Transport – The A449

Issue 1: The 1.8km section of the A449 immediately to the north of J2-M54 is missing from the Applicant's Appendix 11.5 data/analysis.

Plot Date: 27 February 2020 12:49:19
File Name: \\UK6s2p\psw001\1\1\1\ENVIRONMENT\Practice Areas\GIS\Projects\M54\M6 Link\Workspace\Stage 3 Figures\Landscape and Environment- Noise and Vibration\HE514465-ACM\EGN-M54_SW_PR_Z-DR-LN-0005 - Figure 11.4 - Short Term Change.mxd

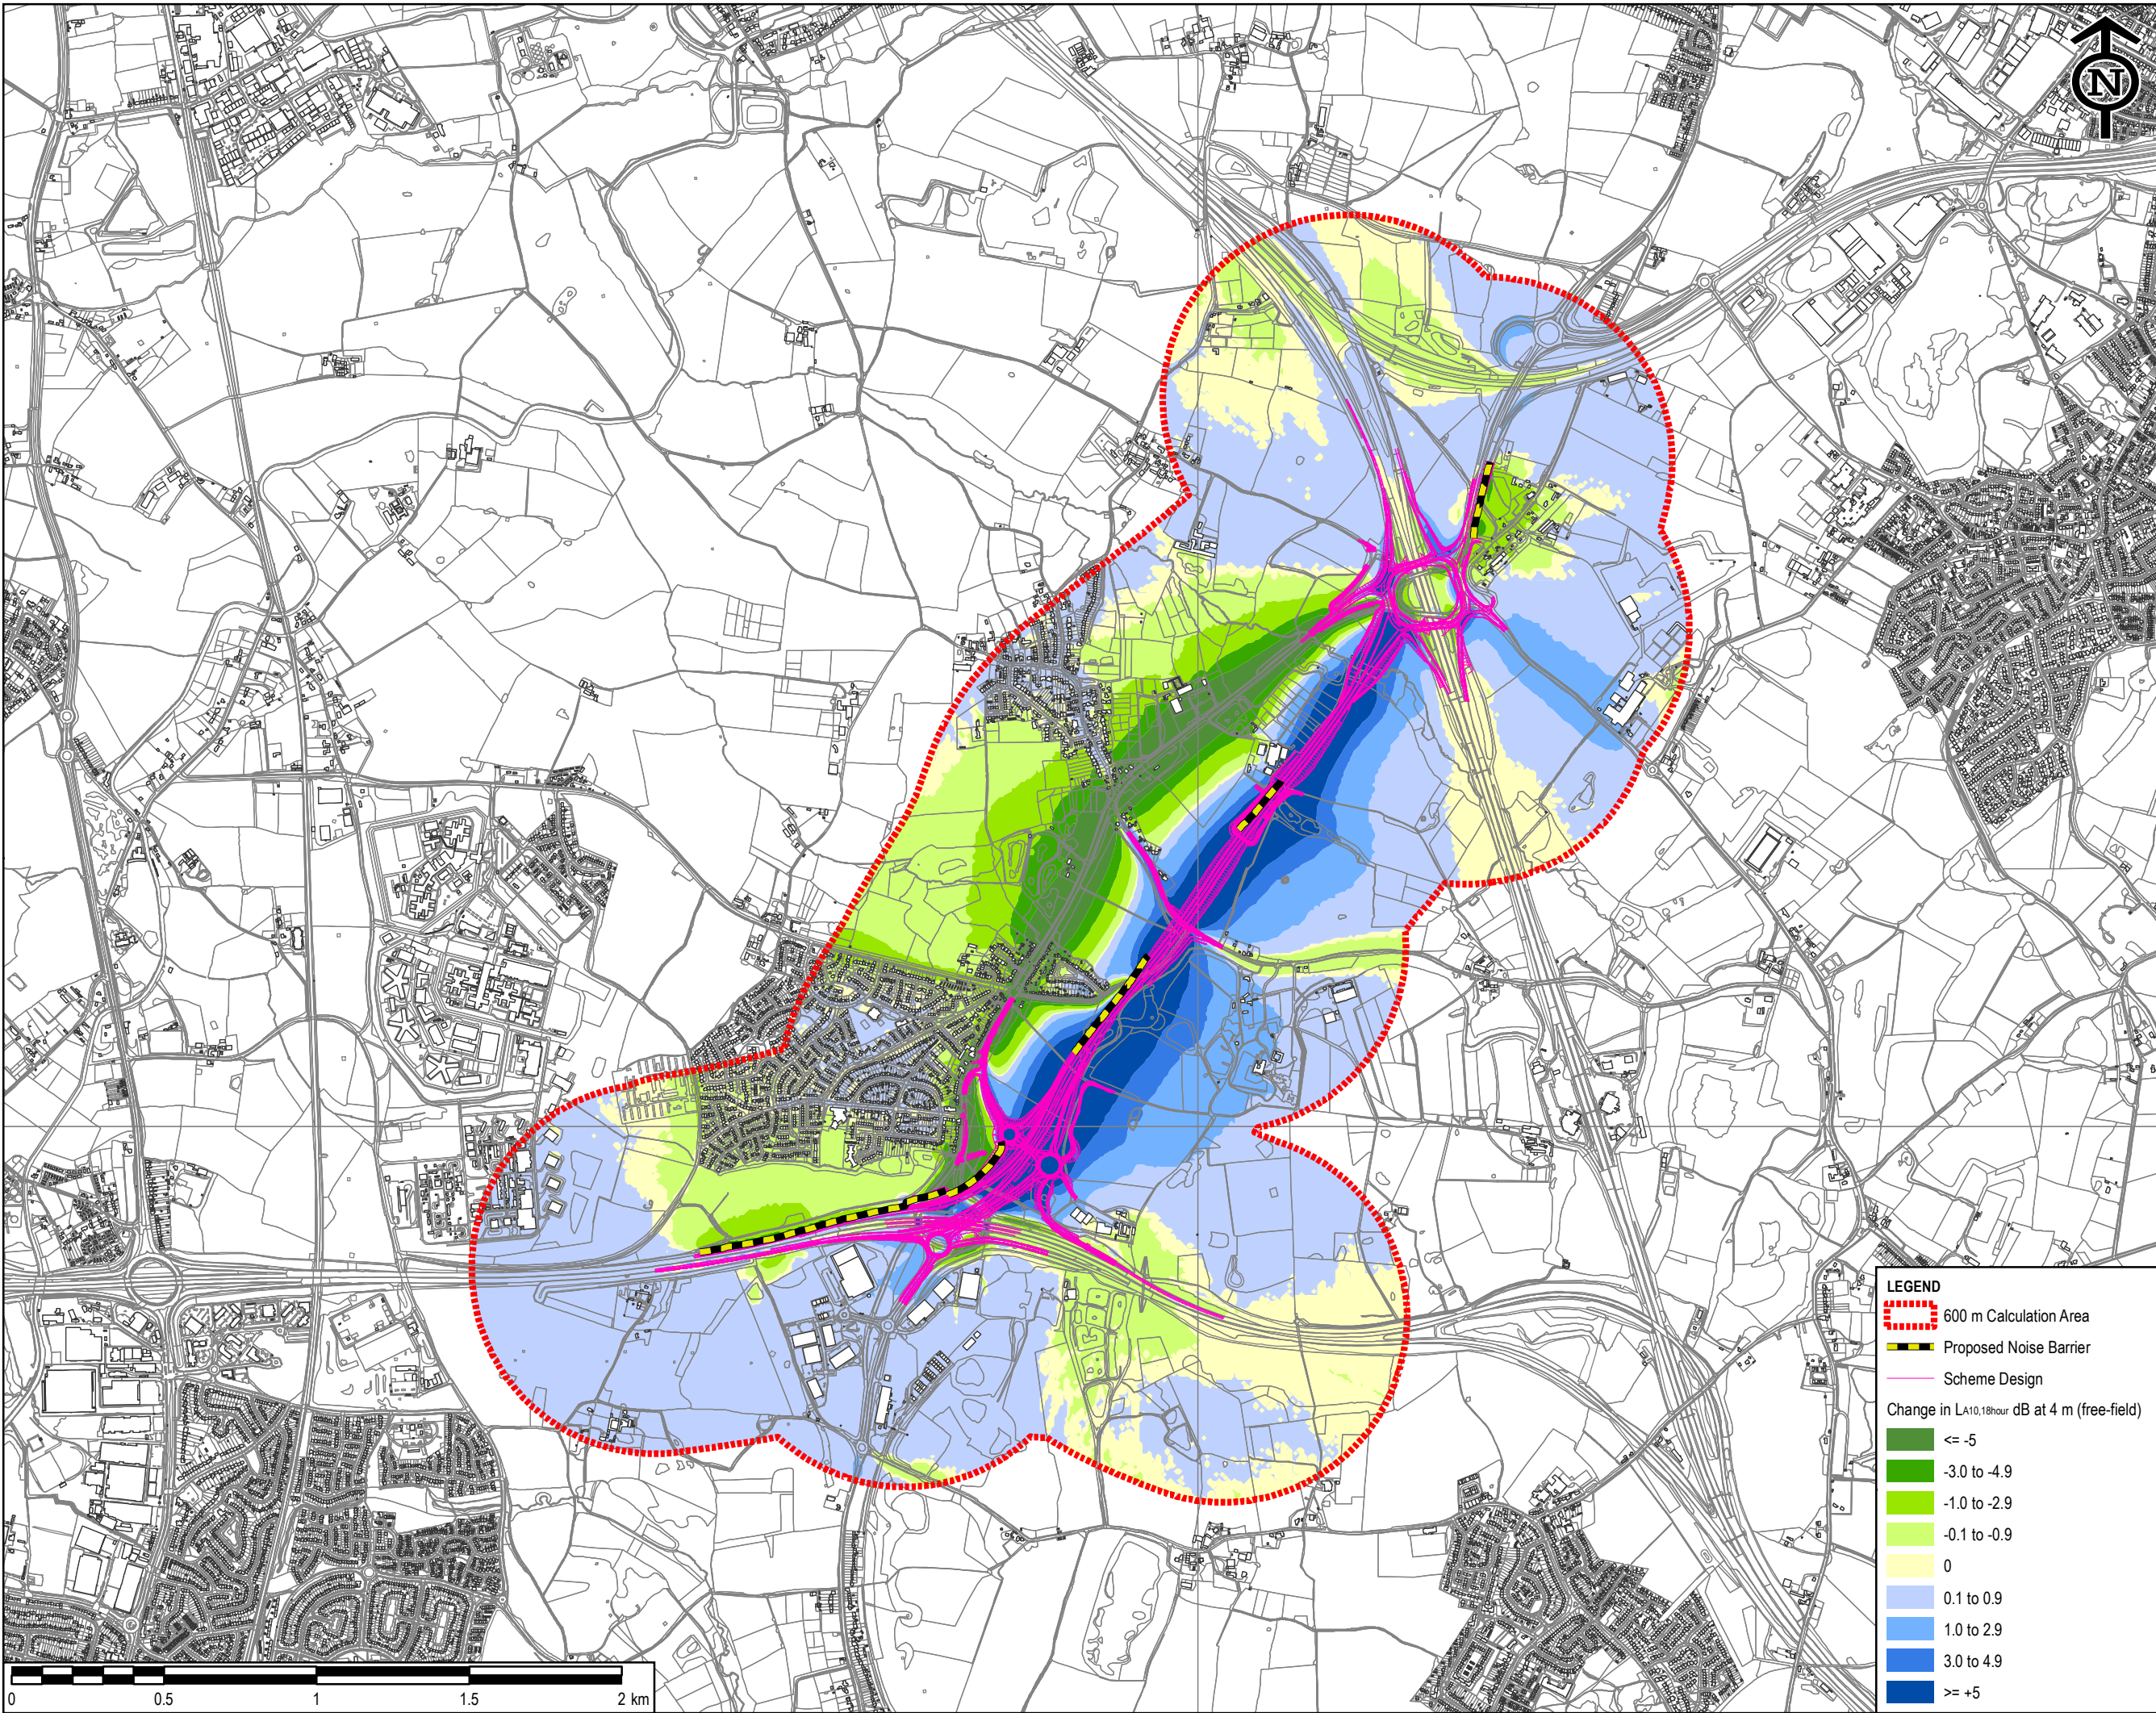
Question 1: The A449 (T) is only 6km overall in length. If the 1.8km stretch of the A449 to the north of J2-M54 is not experiencing a drop in noise of 1dB or more, is the proposed DCO sufficiently effective at putting the right traffic, on the right roads, at the right levels?

Drawing Title
**LAND PLANS
 REGULATION 5(2)(i)
 SHEET 1 OF 10**

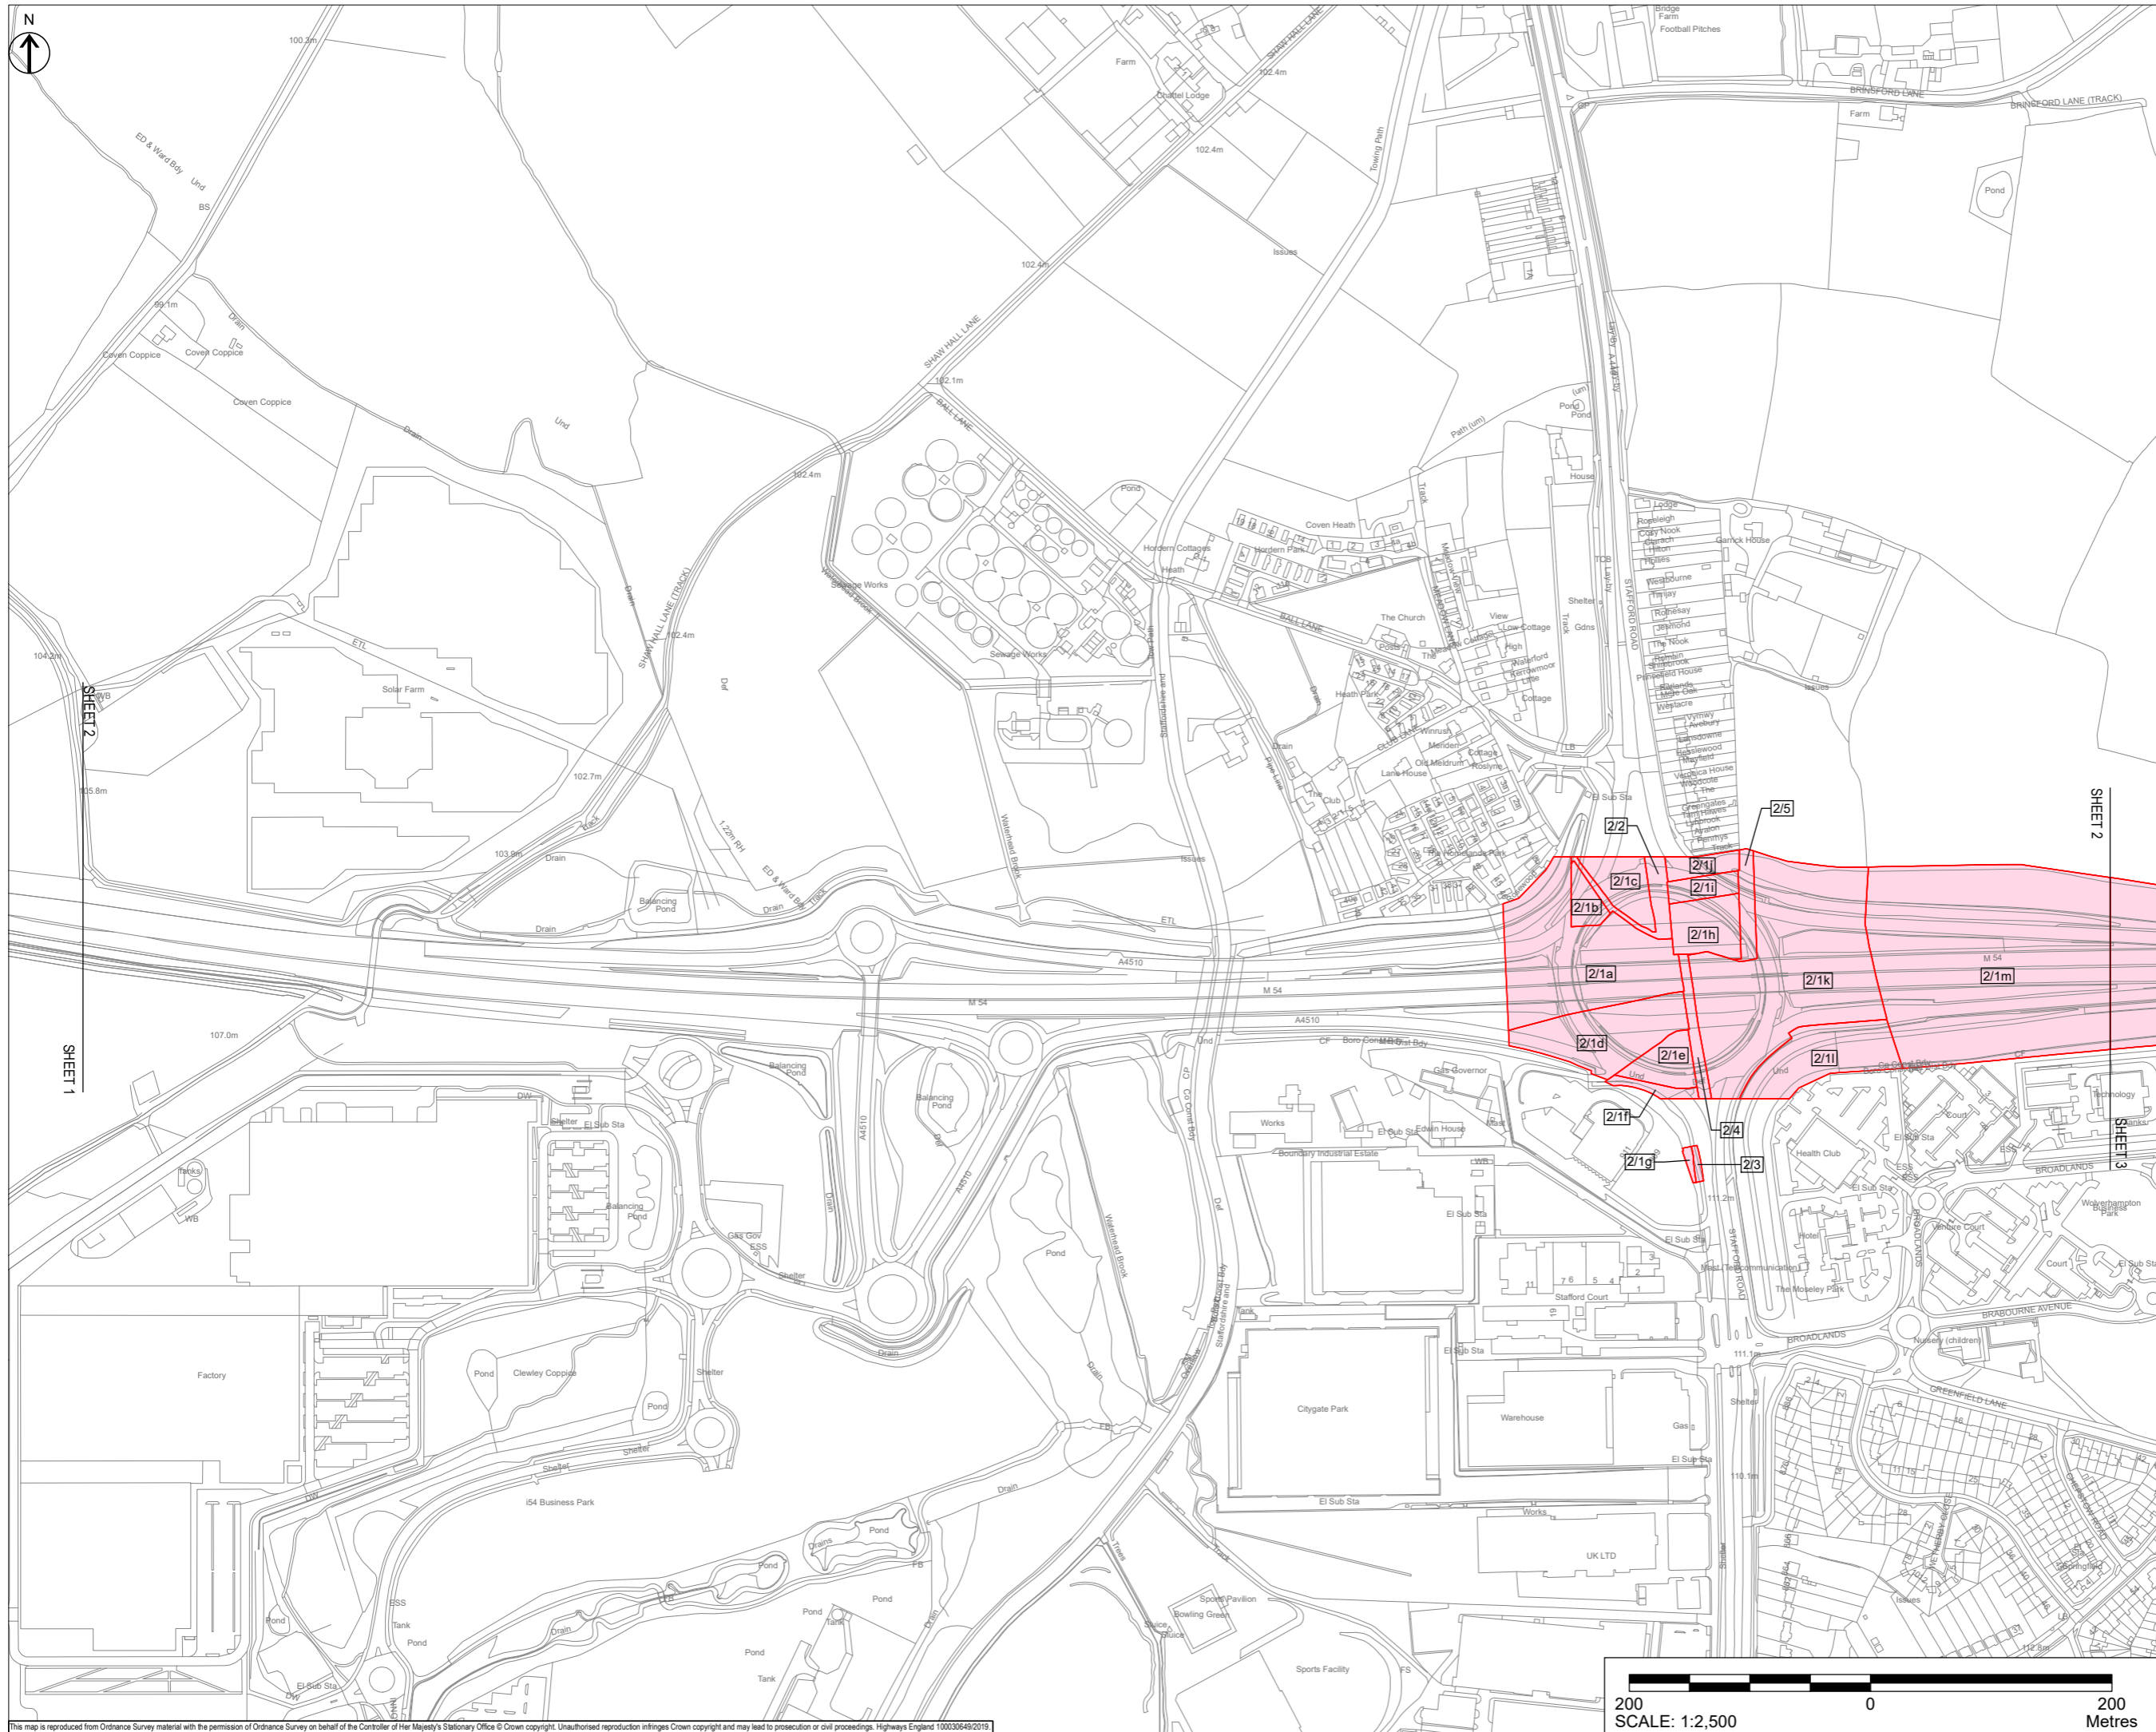
Question 3: How many of the A449 dwellings to the north of J2-M54 reside within 600m of the actual Order limits²?

² LAND PLANS REGULATION 5(2)(i) SHEET 2 OF 10 - -DR-LR-1002 – Rev P06 [TR010054-000110-TR010054 M54 2.2 Land Plans.pdf \(planninginspectorate.gov.uk\)](#)
